Your Ref :
Our Ref : FP/109/18/NMA

Section 96A of the Town & Country Planning Act 1990 (as amended)
Town and Country Planning (Development Management Procedure) (England) Order 2015 (as amended) - Article 10

Non-material amendment following the grant of FP/127/17/PL relating to approved plans for proposed plot plan, ground floor plan, elevations, site & location plans & street scene elevation. 2 Second Avenue, Felpham, ,

PROPOSED GROUND FLOOR PLAN

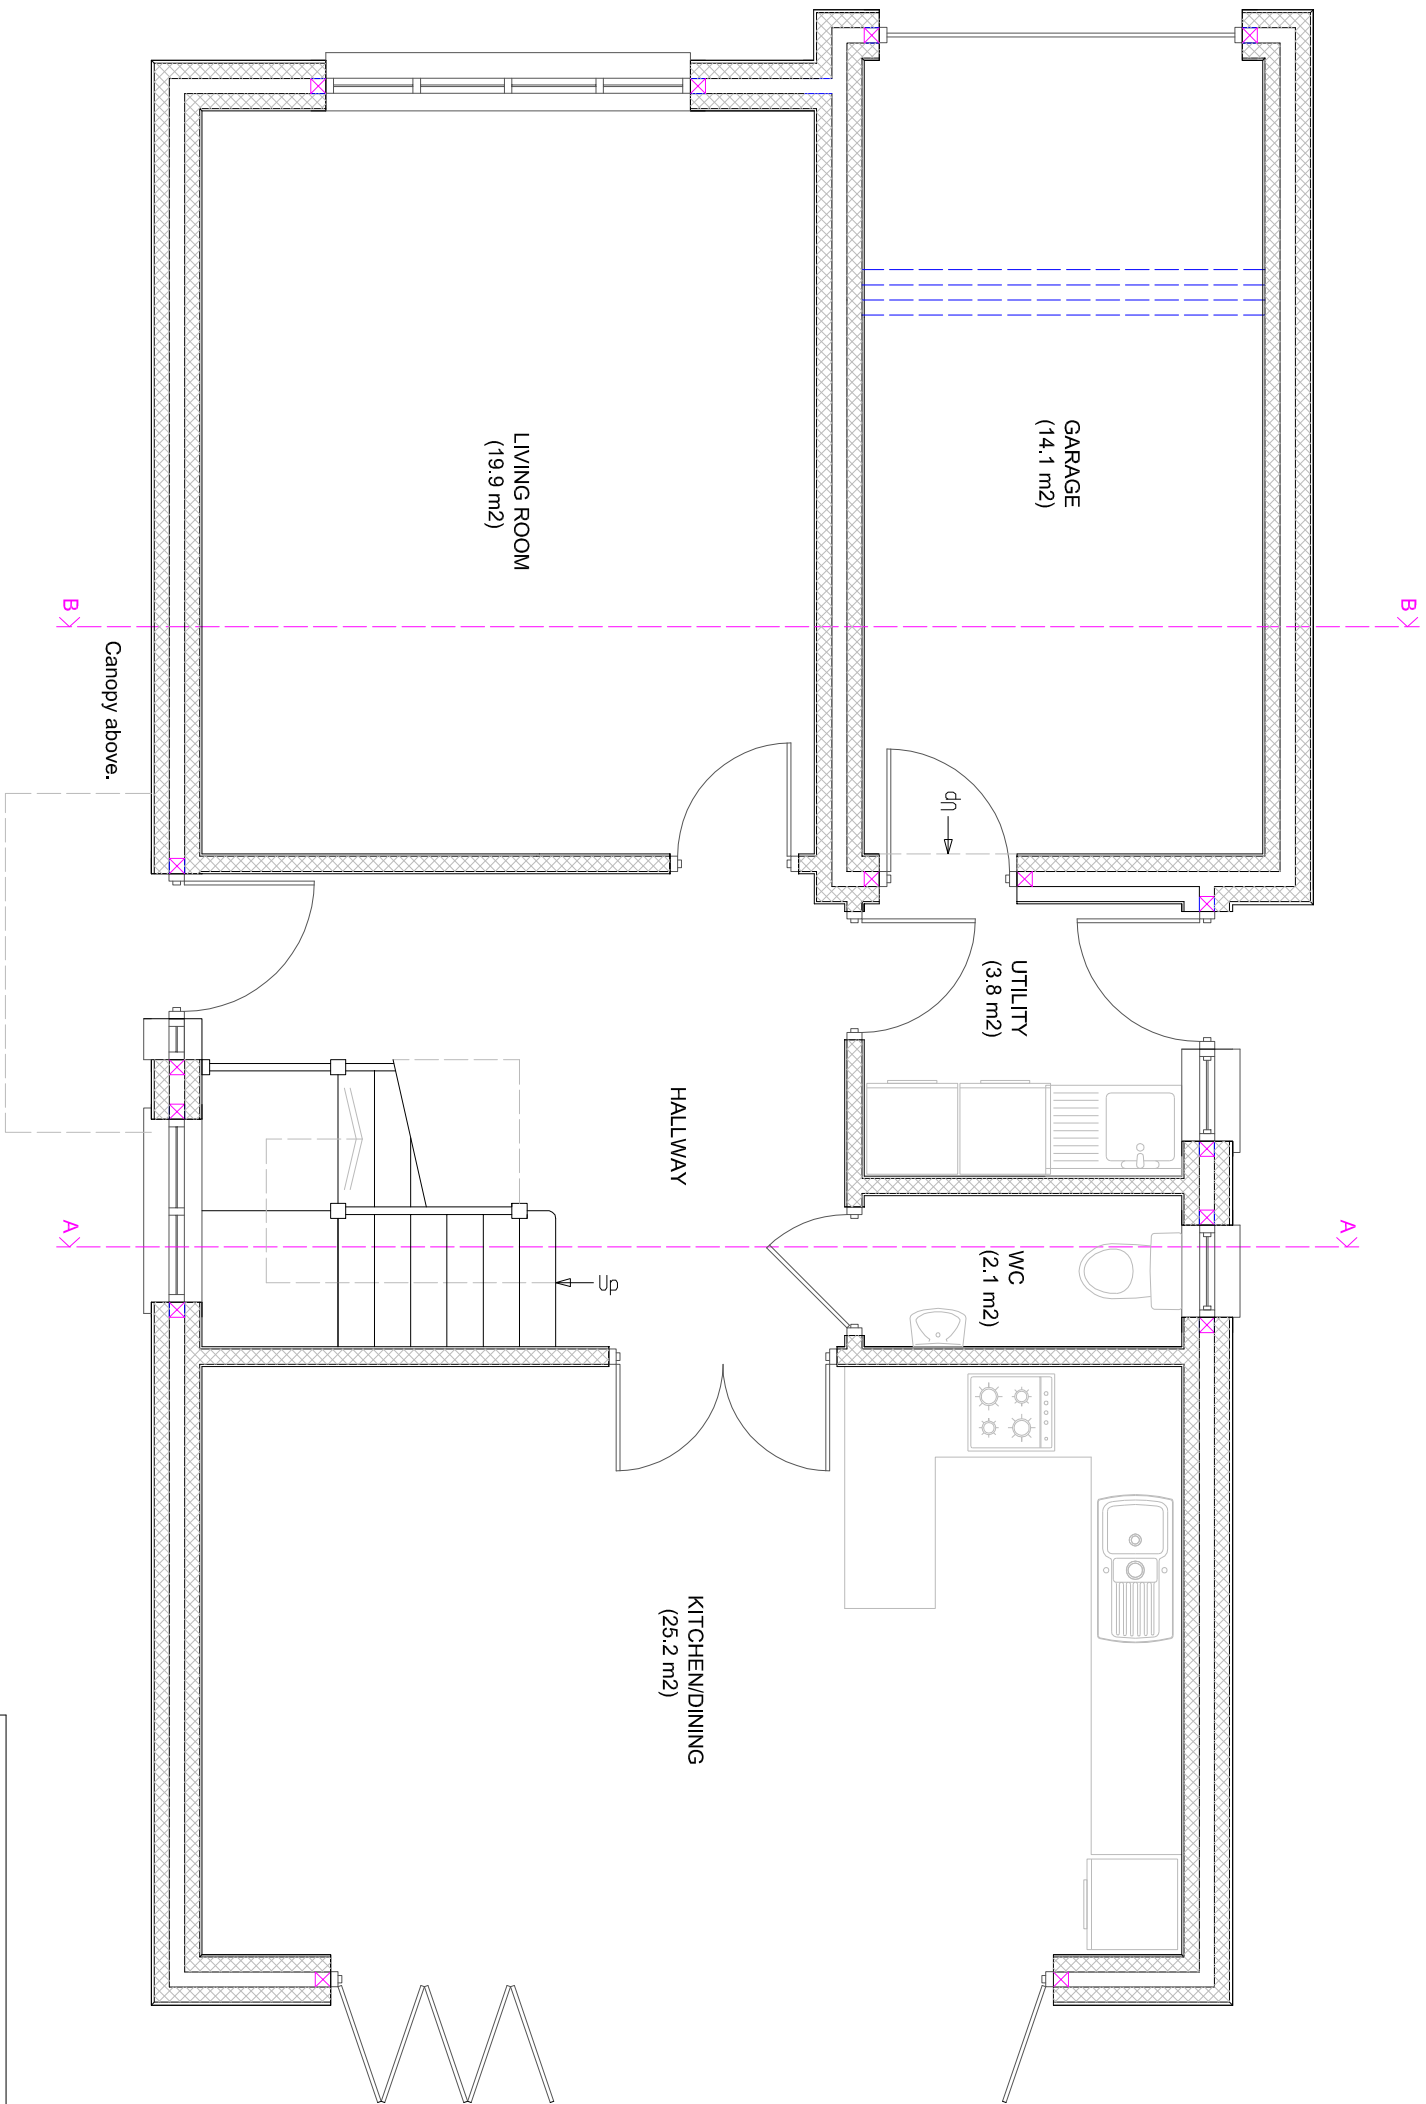
- (a) change the approved internal layout of the ground floor by relocating the entrance door from the front to the side (no change in footprint)
- (b) New door on the front;
- (c) Revised position of 2 windows & 1 door on the side elevation (ground floor);
- (d) New pitched roof canopy above the side entrance door (around 0.75m high)
- (e) Widening of the vehicular access from 3m to 3.5m;

Proposed Plot Plan - Rev B (25/04/18);
Proposed Ground Floor Plan - Rev G (25/04/18);
Proposed Elevations - Rev E (25/04/18); and
Proposed Street Elevation (25/04/18).
